Our Ref: TR010064

Date: 28 January 2025

Application by National Highways for an Order Granting Development Consent for the M60/M62/M66 Simister Island Interchange Project

The Examining Authority (ExA) writes to the parties listed above, under rule 17 of the Infrastructure Planning (Examination Procedure) Rules 2010, following deadline (D) 5 on Friday 10 January 2025. Having reviewed the documents submitted at this deadline the ExA requests the following further information and clarifications.

FIGURE 2.3

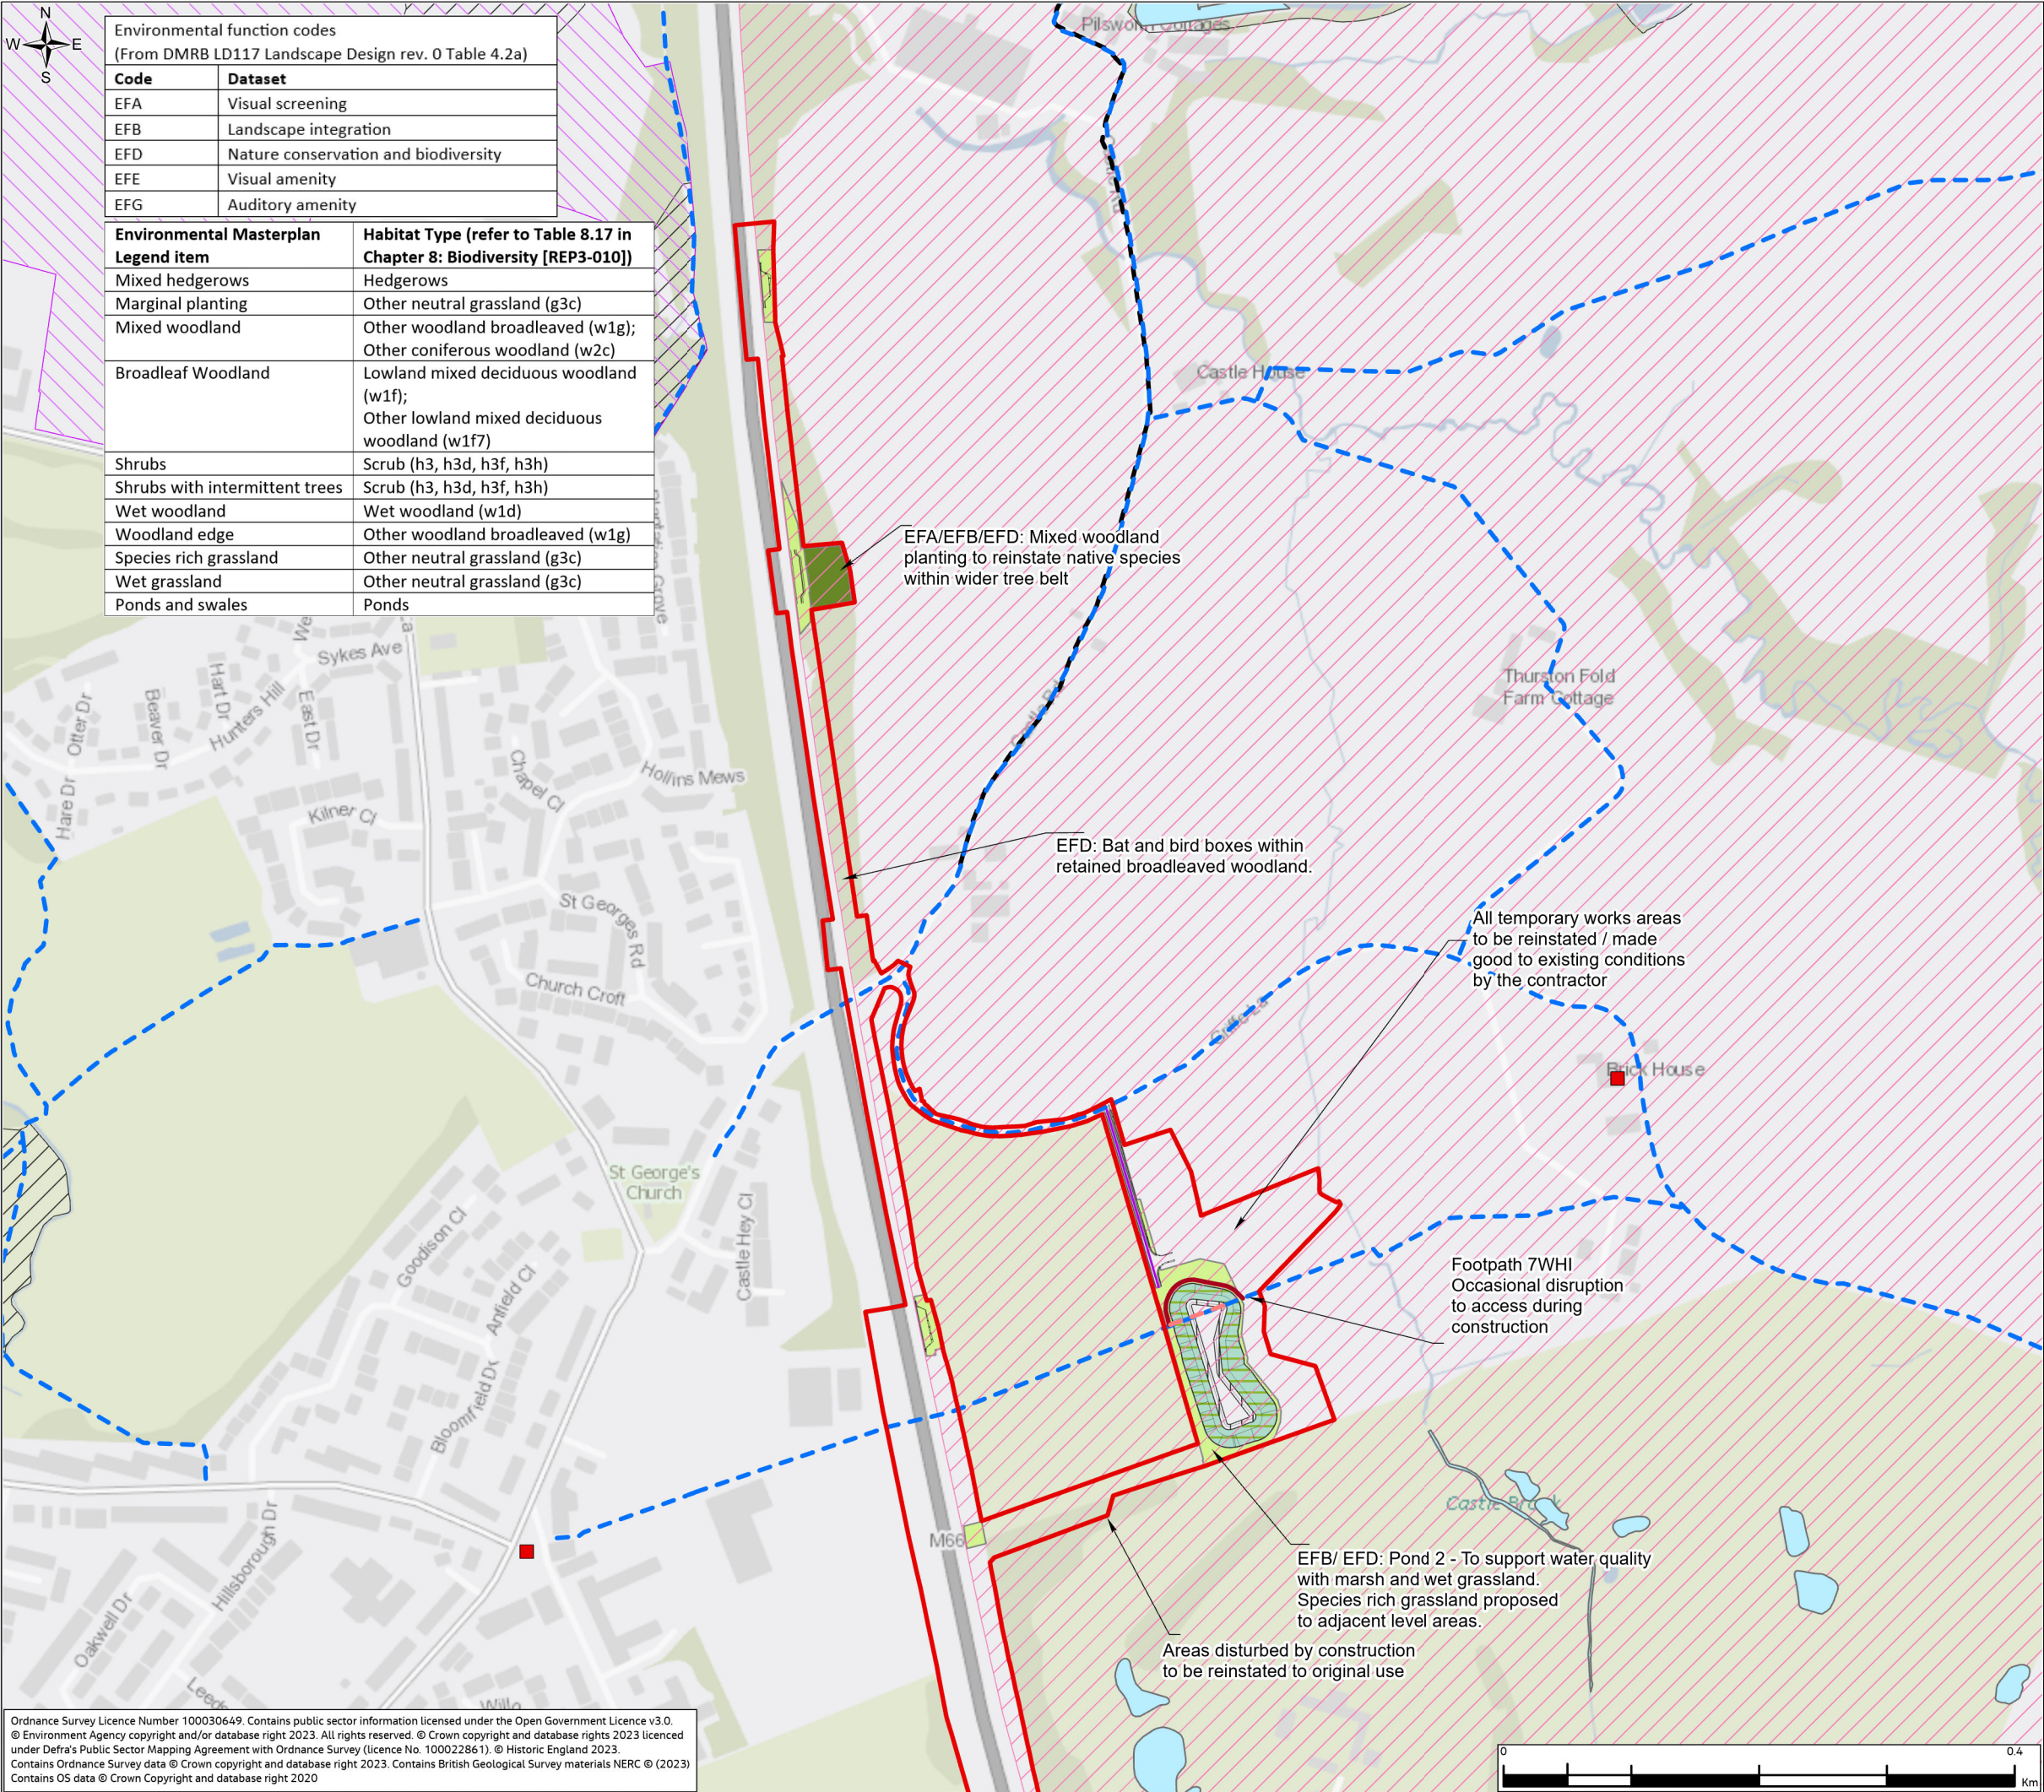
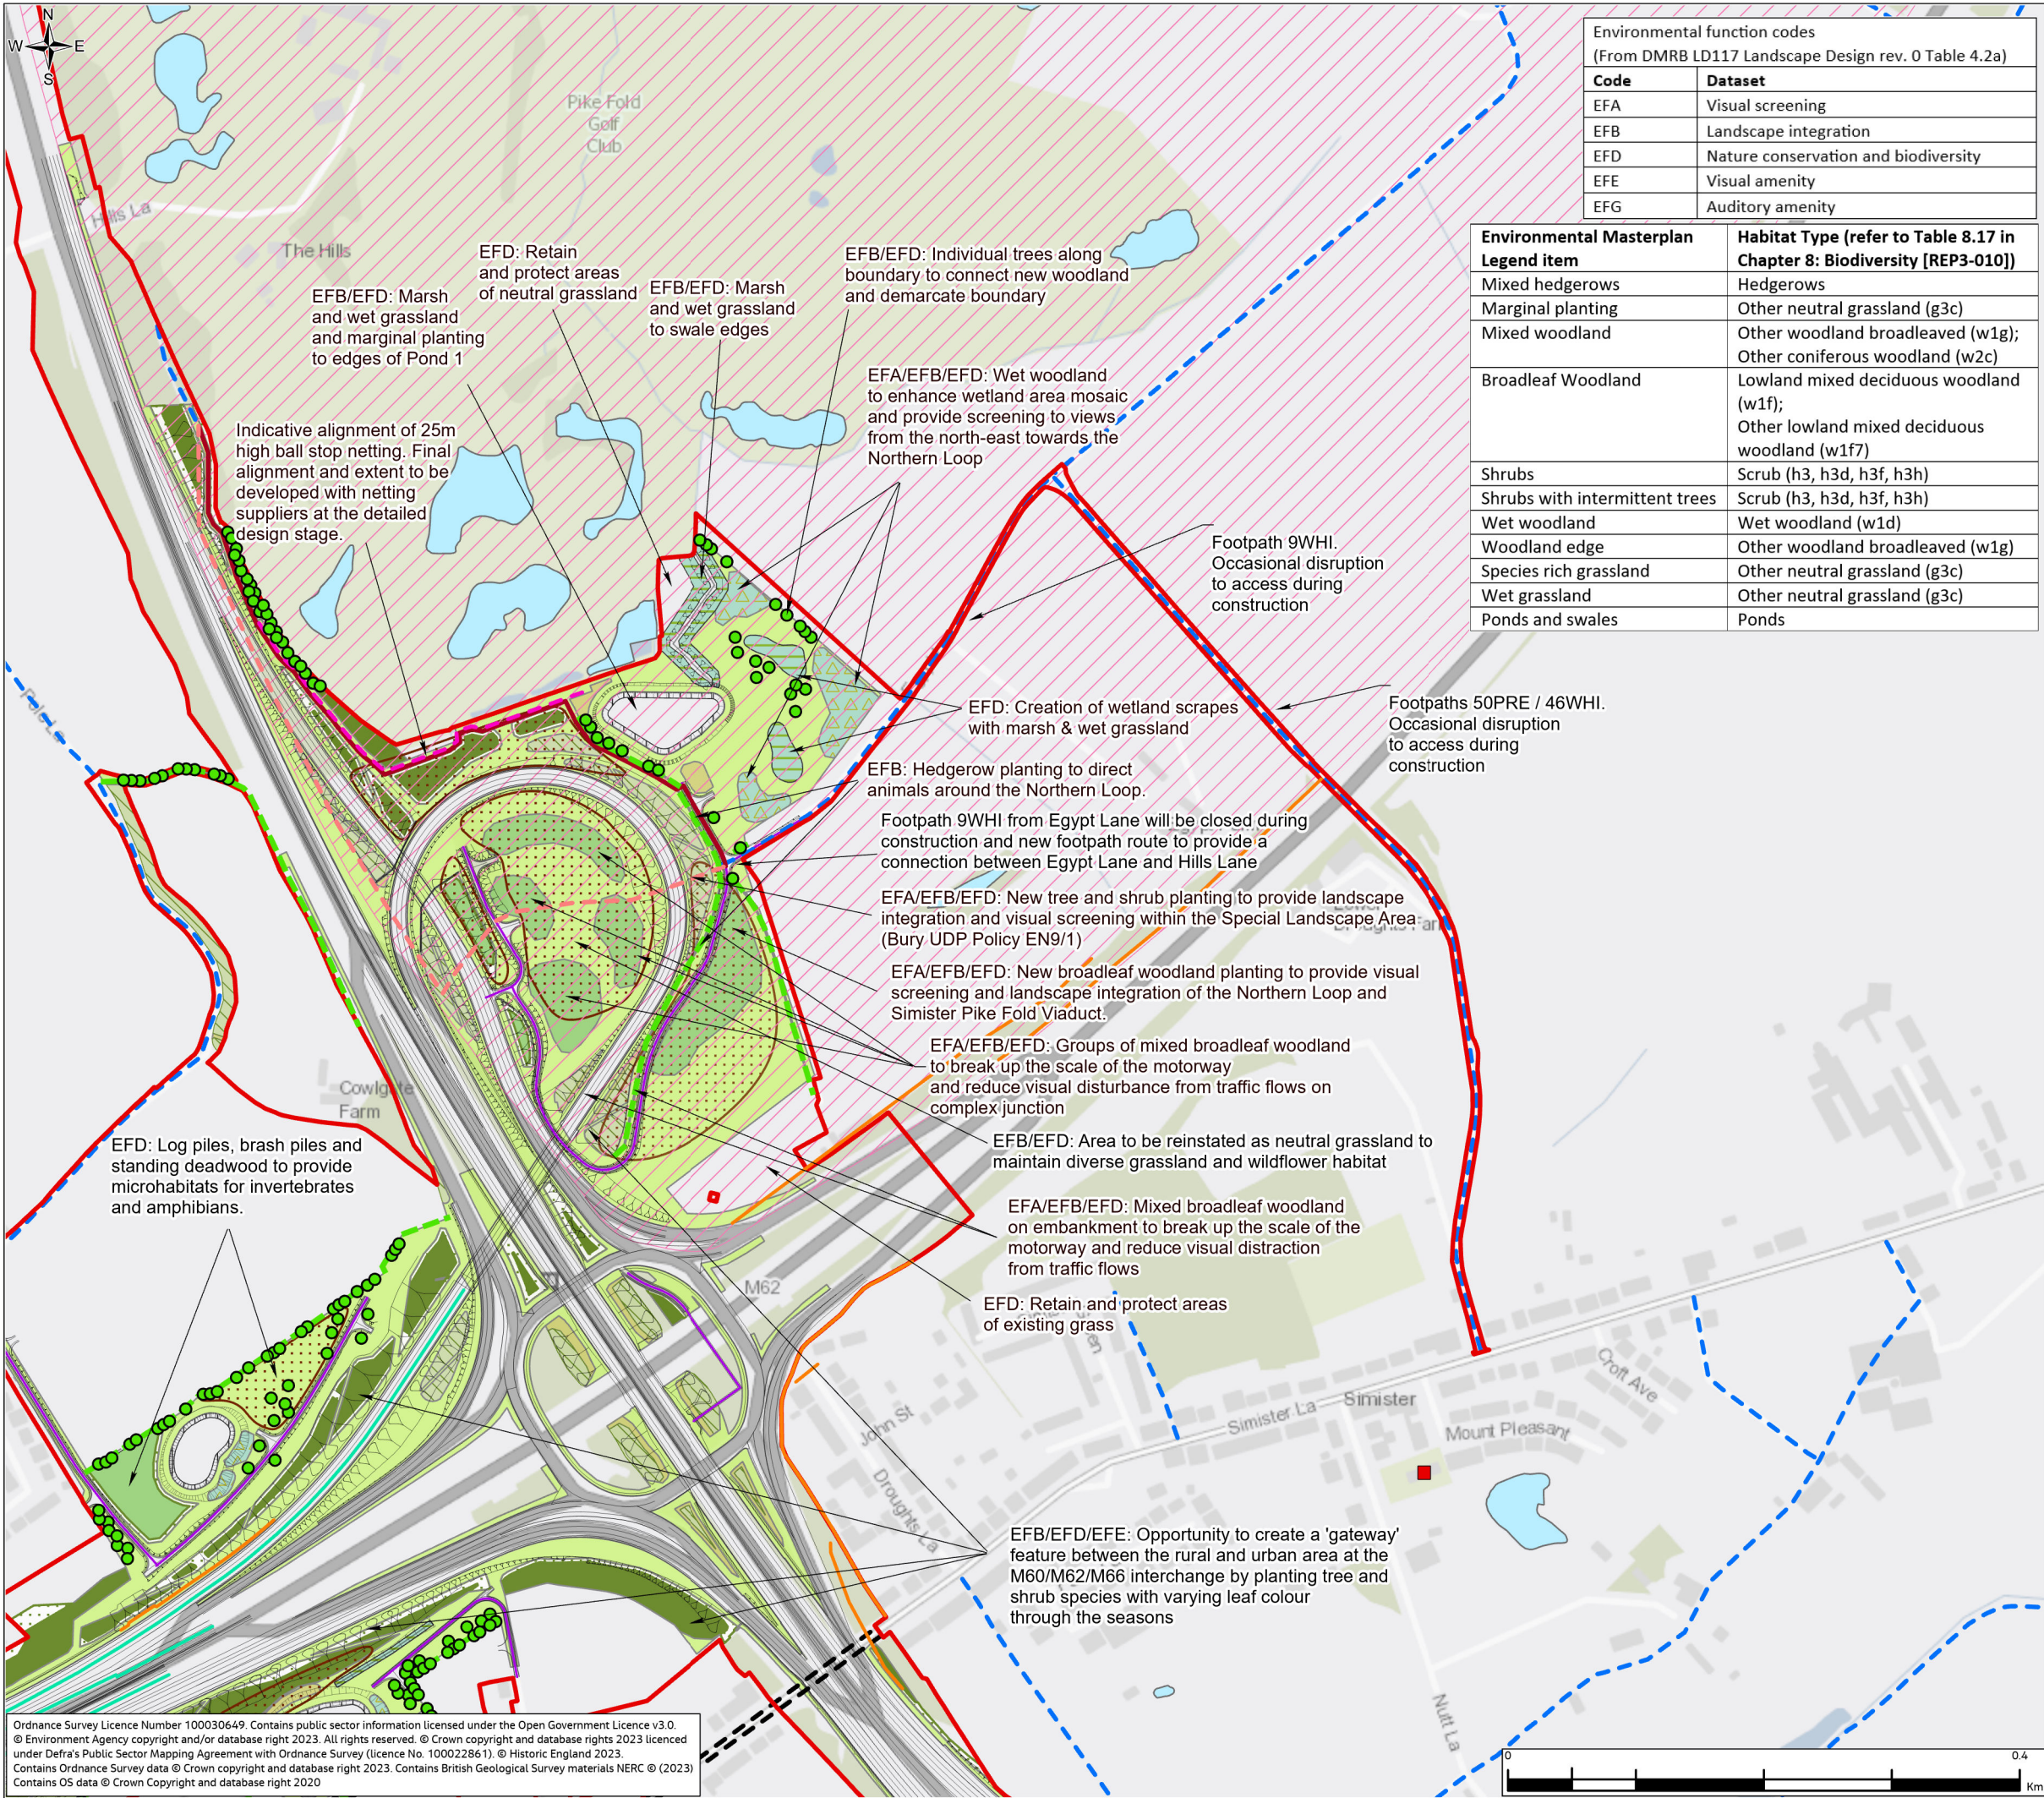
- Confirm the environmental function code for the broadleaf woodland proposed in land plot 2/16b on [REP5-017].
- Notwithstanding any tree and shrub planting proposed to the embankments of the proposed northern loop and Pike Fold Bridge, explain how the proposed areas of broadleaf woodland, areas of wet woodland and individual deciduous trees [REP5-017] across land plots 2/16b and 2/16d contribute to reducing the significant effects identified in [REP4-020] at the visual receptors represented by viewpoints 3, 5 and 7.

- Figure ExQ2 BIO2.2 [REP5-033] identifies an area within plots 2/16b and 2/16d as 'habitats to be enhanced'. However, Figure 2.3 [REP5-017] annotates these areas for nature conservation and biodiversity purposes to 'retain and protect areas of existing grass'. Explain how these areas can be considered an enhancement if they are proposed to be retained and protected. In addition, explain further why an existing area to be retained and protected requires compulsory acquisition.
